Appeal NO: ~~ACP~~ ABP-322154-25Defer Re O/H ☐Having considered the contents of the submission dated/ received 24/11/25
fromMichael Egan I recommend that section 131 of the Planning and Development Act, 2000
be not invoked at this stage for the following reason(s): No new planning issuerE.O.: Daniel O ConnorDate: 25/11/25

From: Michael Egan <michaelegan012@gmail.com>
Sent: Monday 24 November 2025 09:26
To: Appeals2
Subject: Briskalagh Appeal.
Attachments: Michael Egan Submission 24 11 2025.docx

An Bord Pleanála Planning Reference	ABP-322154-25
KCC Planning File	256003
Name	Briskalagh Ltd.
Address	In the townlands of Acragar, Ballyconra, Ballycuddihy, Ballyroe, Ballyroe (Grace), Ballyroe (Maher), Baunaniska, Boherkyle, Briskalagh, Brittas, Clone, Coolnapisha, Curraghduff, Freshford, Freshford Lots, Graigueswood, Grange, Huntstown, Kilmanagh, Knockeenglass, Knockown, Moatpark, Monabrika, Monavadaroe, Moneenaun, Oldtown, Oldtownhill, Parksgrove, Picketstown, Rathealy, Sart, Sweethill, Tobernapeastia, Tullaroan, Upperwood Demesne, Co. Kilkenny.

1. Purpose of this Submission

Figure 16. New culvert locations.

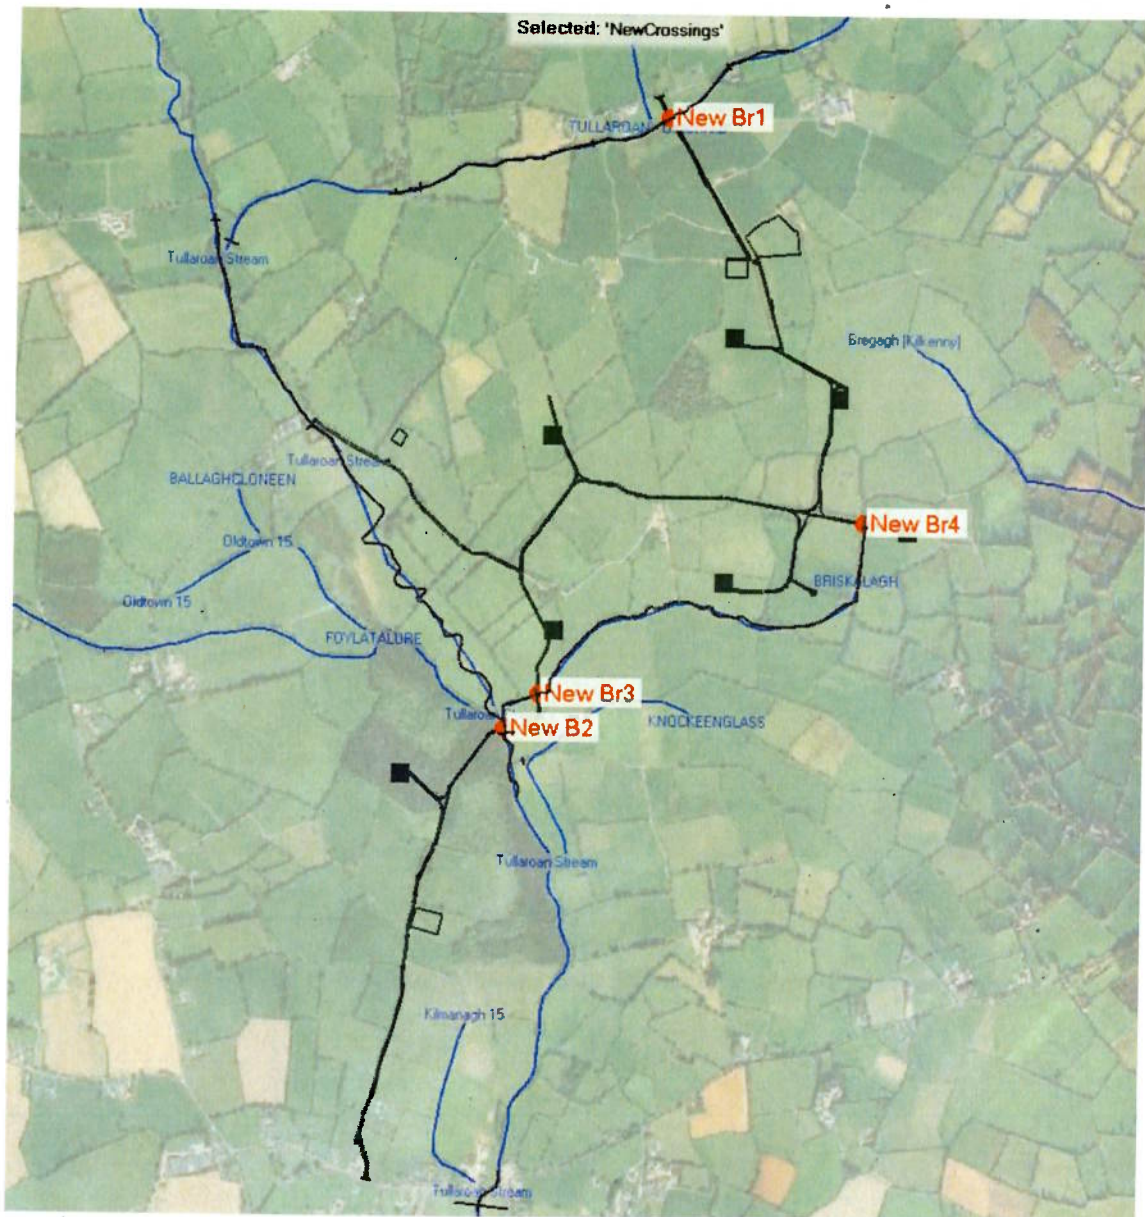
We note the Fluvio R&D Limited report, submitted as part of the appellants Further Information response. Our initial review of this new document finds serious and multiple erroneous statements. One such example can be found on page 50 of the Fluvio R&D Limited report which states that special attention was given to flood levels in Kilmanagh village. In particular, and as highlighted in Figures 33 & 34 of the report, it is explicitly stated that during the occurrence of a Q100cc (1 in 100 year + climate change) or a Q1000cc (1 in 1000 year + climate change) the output of the hydraulic modelling exercise demonstrates that the hurling pitch immediately downstream of Kilmanagh bridge does not flood. **This is a significant and concerning erroneous statement and miscalculation.**

The hurling pitch at this location is known to be subject to flood inundation on a regular basis. Figure 1 below illustrates the hurling pitch following one of three flood events in October and November 2023. And as recently as 11th November 2025, this flooding recurred at this location once again.

This demonstrates that this Site Specific Hydraulic Modelling exercise is significantly flawed and does not provide any confidence whatsoever in relation to the potential adverse impact of the proposed wind farm development on the existing hydrological regime of the area
